CITY OF ALBUQUERQUE

August 28, 2018

Re: Pond Gardens
1800 Candelaria rd
Traffic Circulation Layout
Architect's Stamp **08-20-18** (G13-D036)

TRAFFIC CIRCULATION LAYOUT

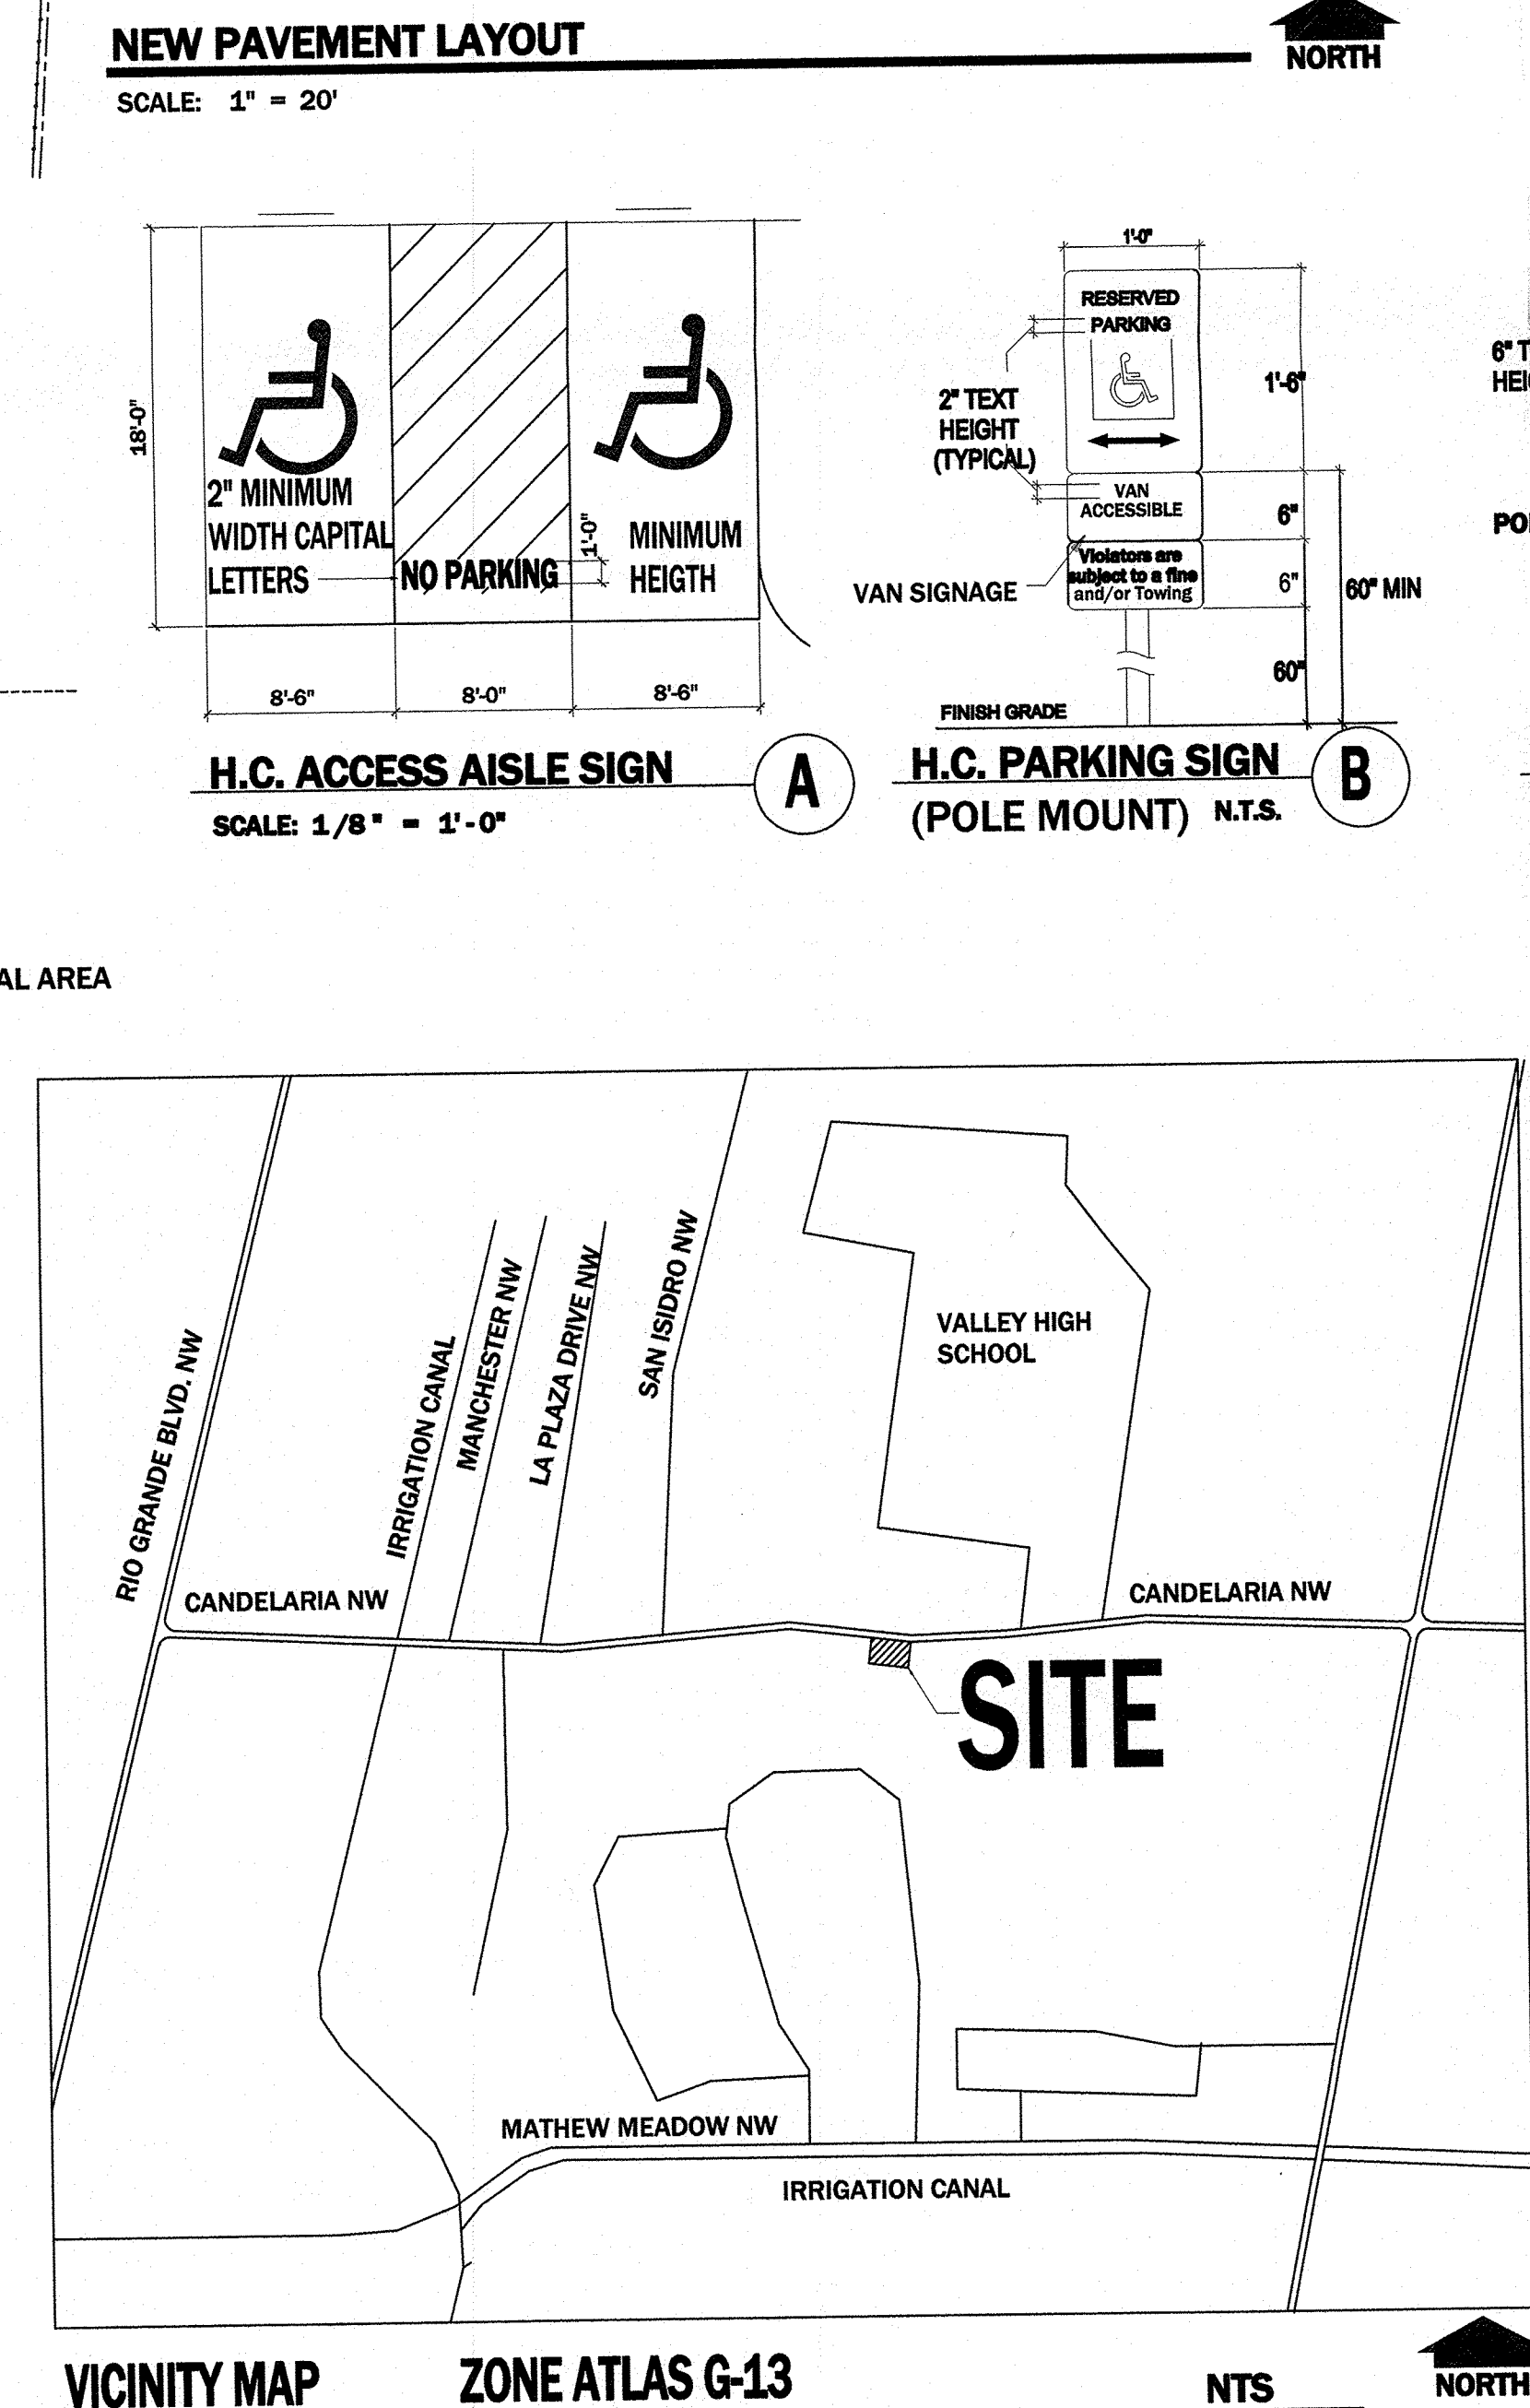
1. One-way vehicular paths require pavement directional signage and a posted **"Do Not Enter"** sign at the point of egress. Please show detail and location of posted signs.
2. The Driveway widths are not wide enough for two way travel and the site is setup for one-way traffic. One way drives on roadways classified as arterial should be 20 feet wide per Ch 23 section 6 of the DPM.
